PROJECT #: 22-1674-B

DATE: September 8, 2023

LOCATION: Lot 32, Prince Place

PLANS REF: Lot 32, Prince Place by Murphy Garnow Design Group Project #: 22-1674

FIRST FLOOR CEILING STRUCTURAL PLAN
SCALE: ----- 1/4" = 1'-0"
9'-0" CLG. HGT.

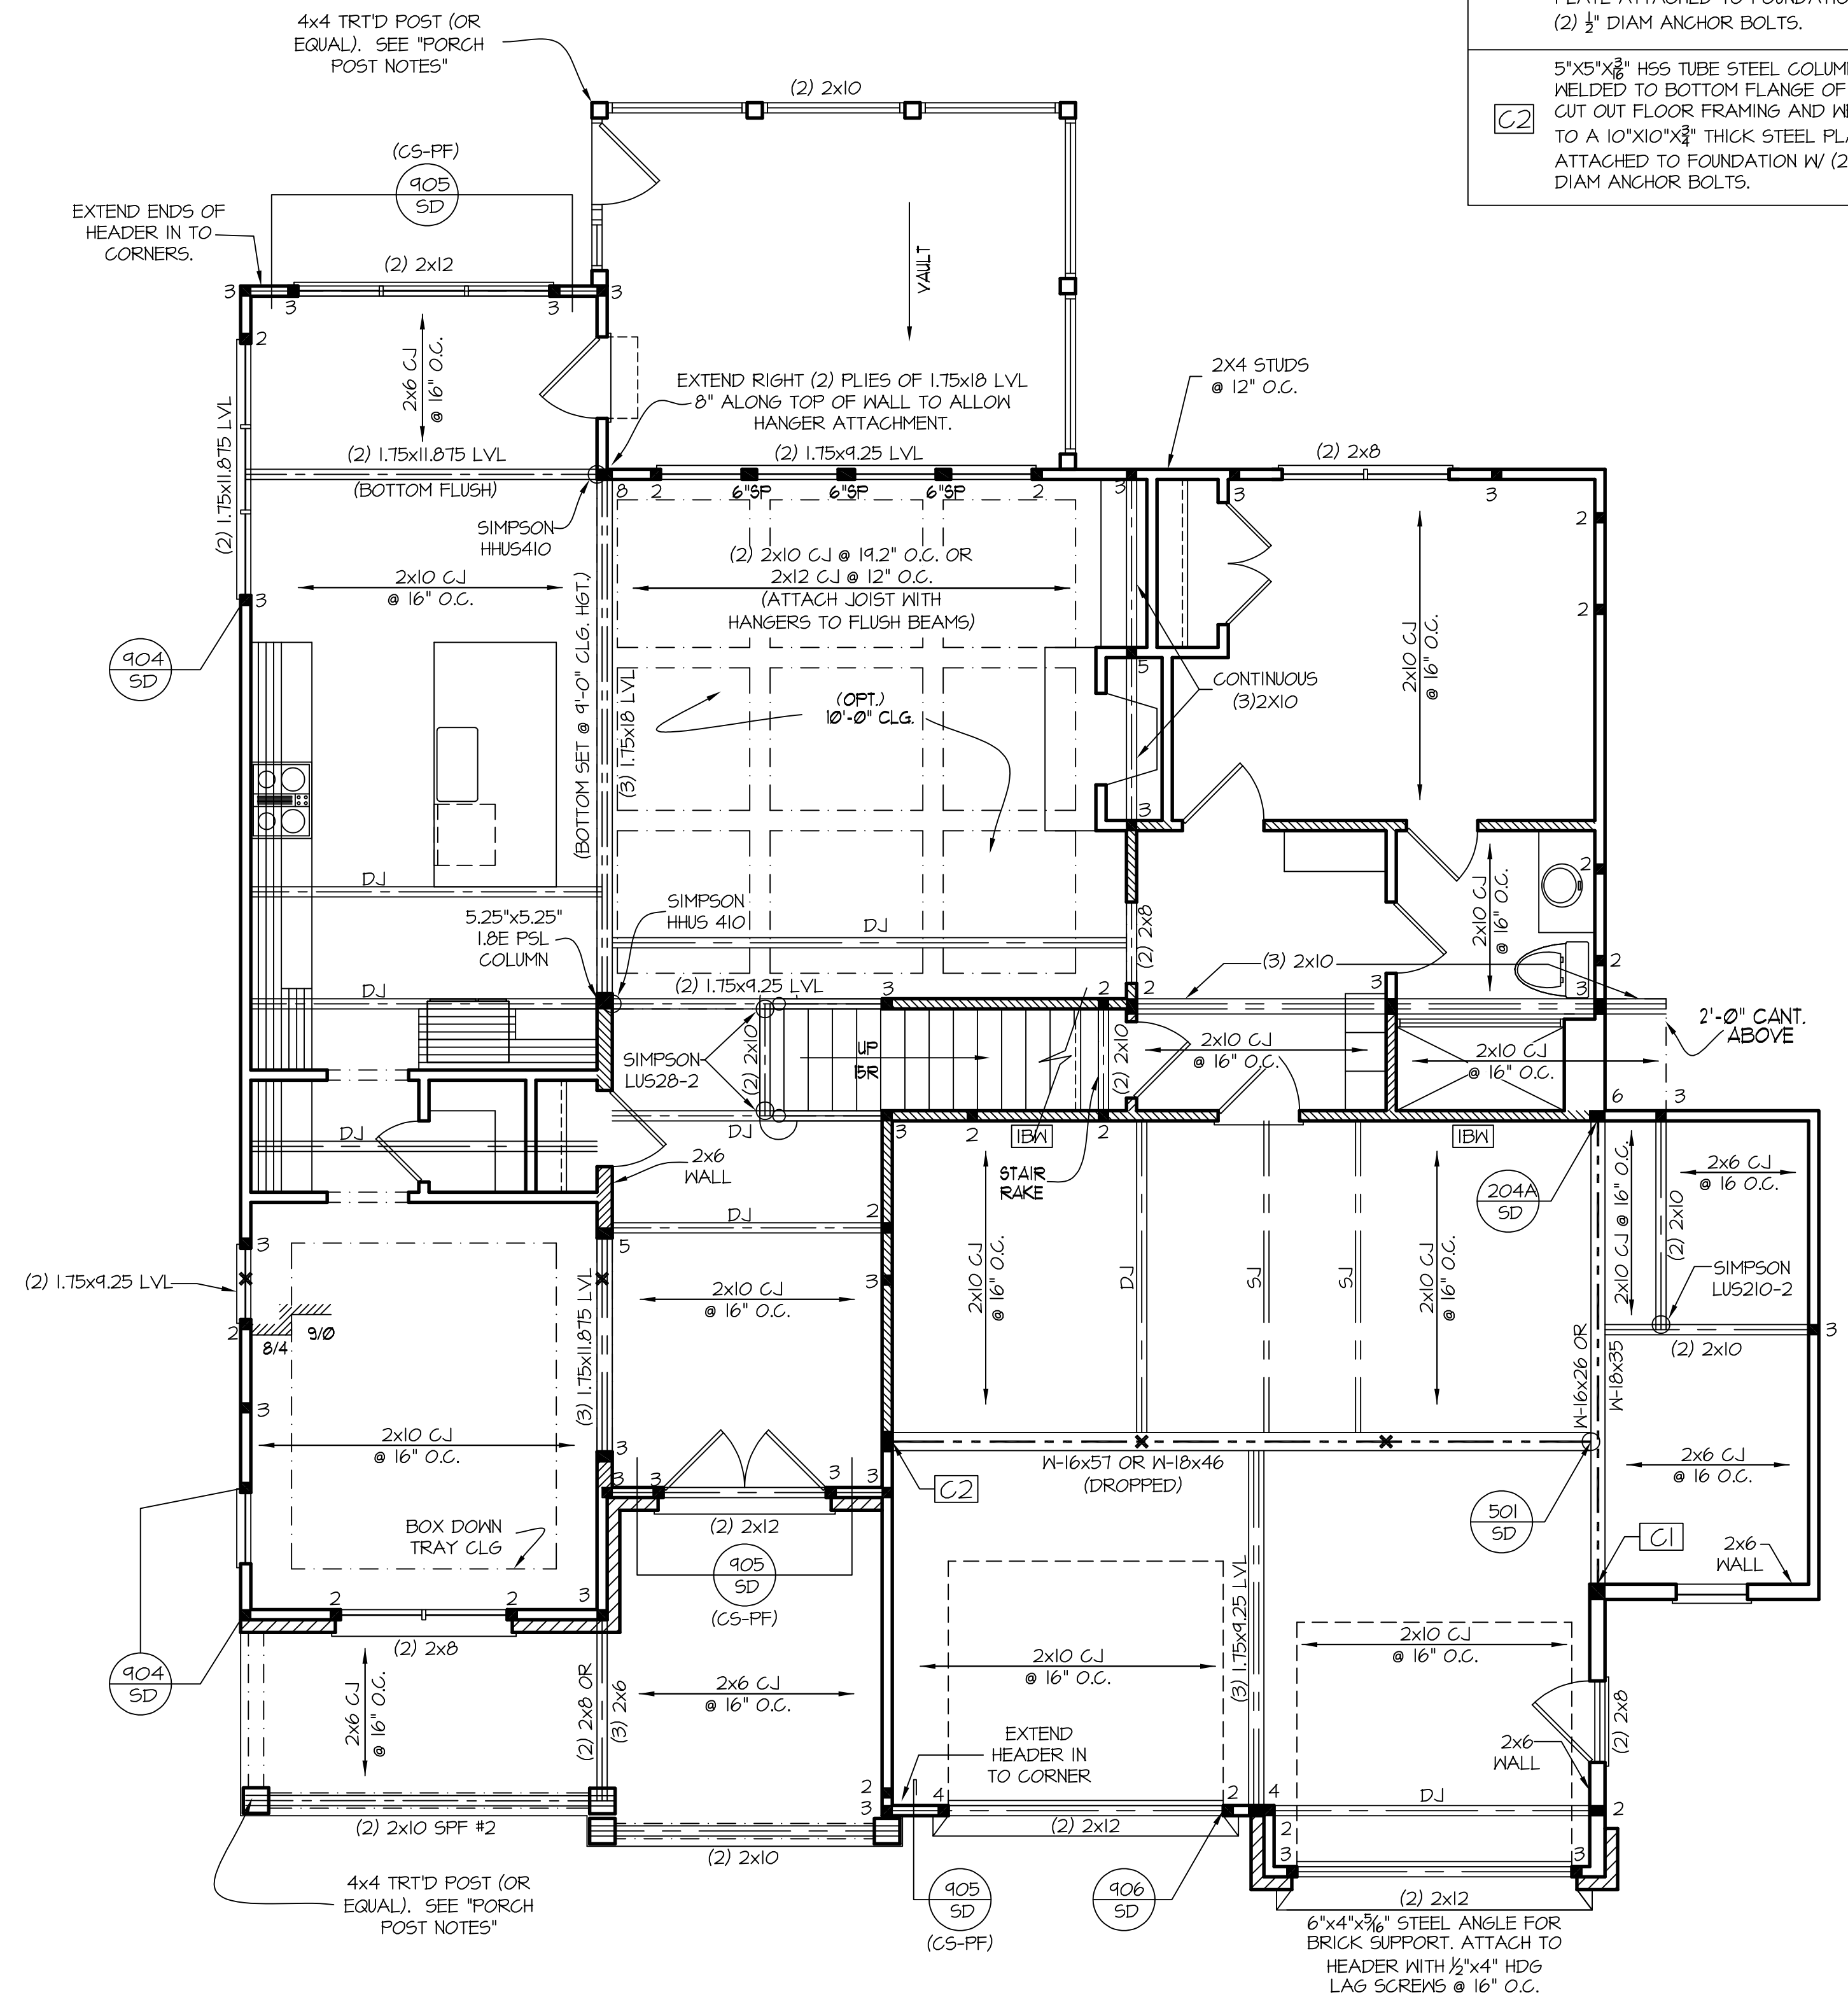
Porch Post Attachment: Page seven of the plans shows porch posts labeled as “4x4 treated post (or equal), see porch post notes”. Please be advised that the connectors listed in the “Porch Post Notes” are recommended connectors only. Alternative connectors that meet the NC Residential Code, any local codes, and/or the building inspector’s interpretation or approval may be substituted.
